[REDACTED]
Subject: FW: [EXTERNAL] Acknowledgement for WA/31/22/DOC

Please could I request a quick update on the above DOC. This relates to the lighting detail for the Dandara scheme at Fontwell.

Proposed floodlighting

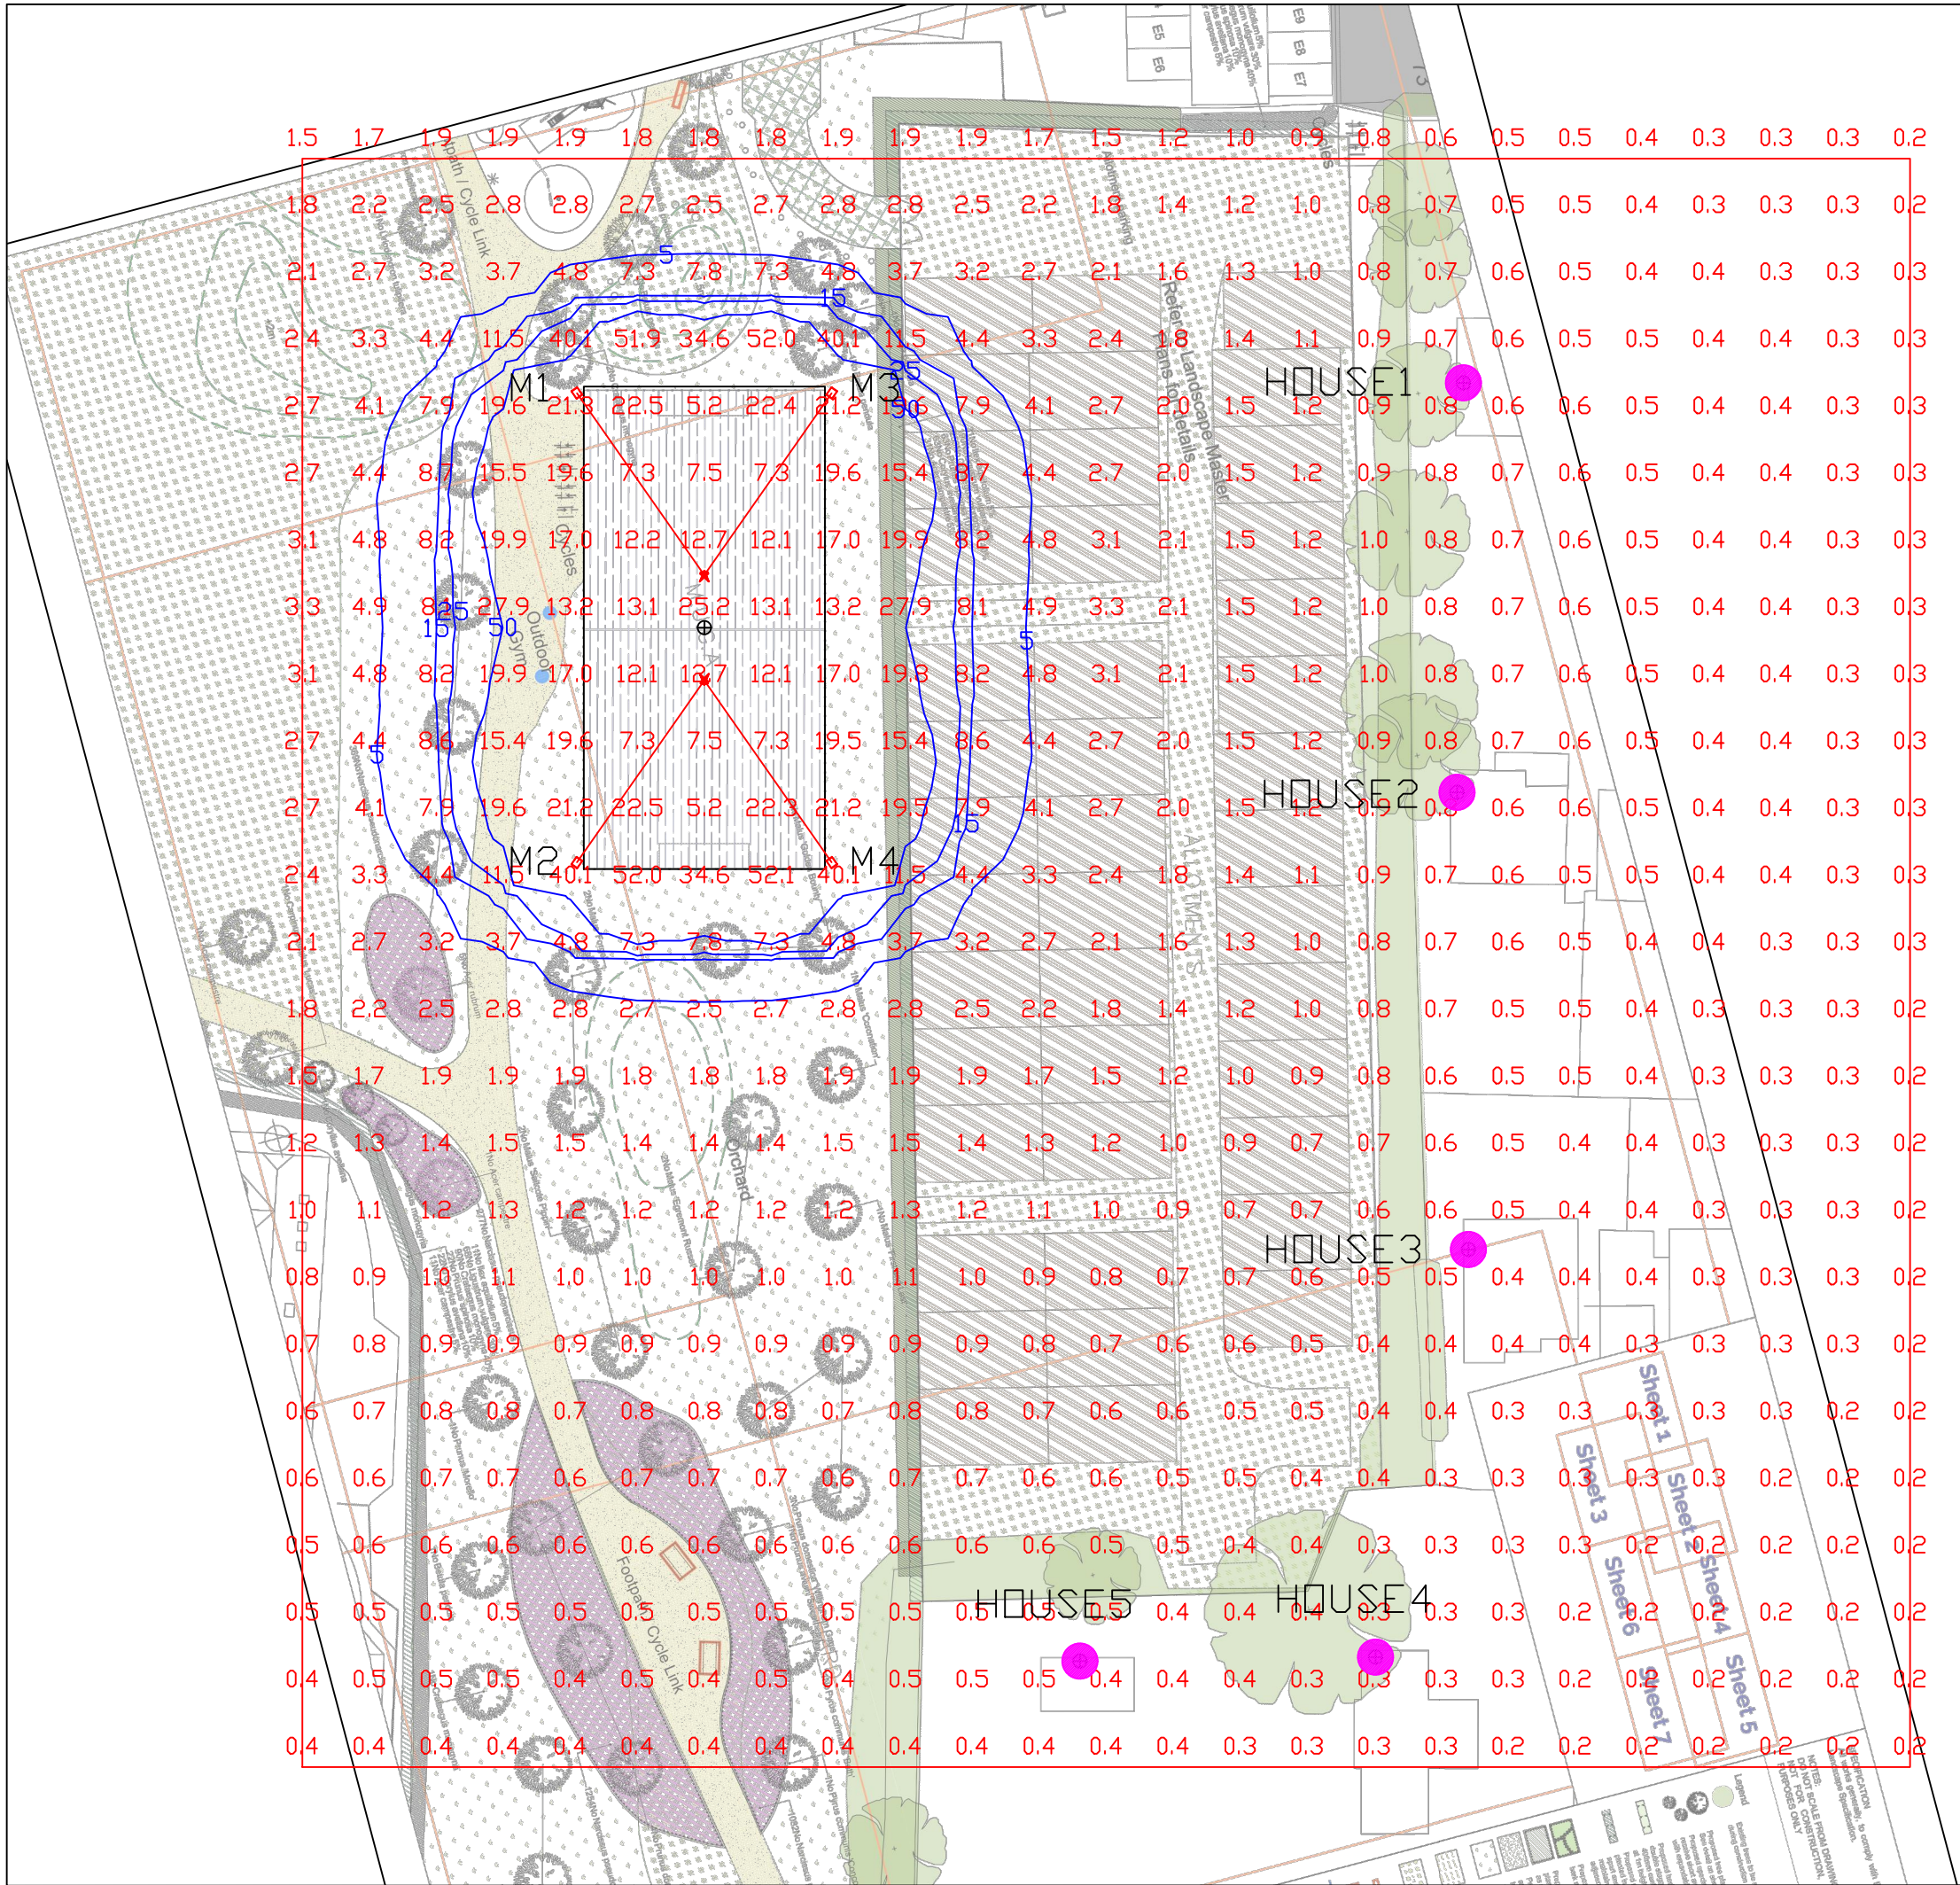
In regards to the below we have received a consultation response from our ecologists who have advised that subject to shields being secured for the proposed floodlighting they have recommended the discharge of Condition 9. I have looked at the proposed floodlighting plan and can see no reference within the notes to shields being installed are you able to confirm and amend if necessary to address this?

Following your email below, we have checked with the designers and they have confirmed that the shields are not required as these are downward directional lights and the upward lux spill is 0. Please see attached updated specification drawing which shows 0 lux spill and therefore no need for the shields to be attached.
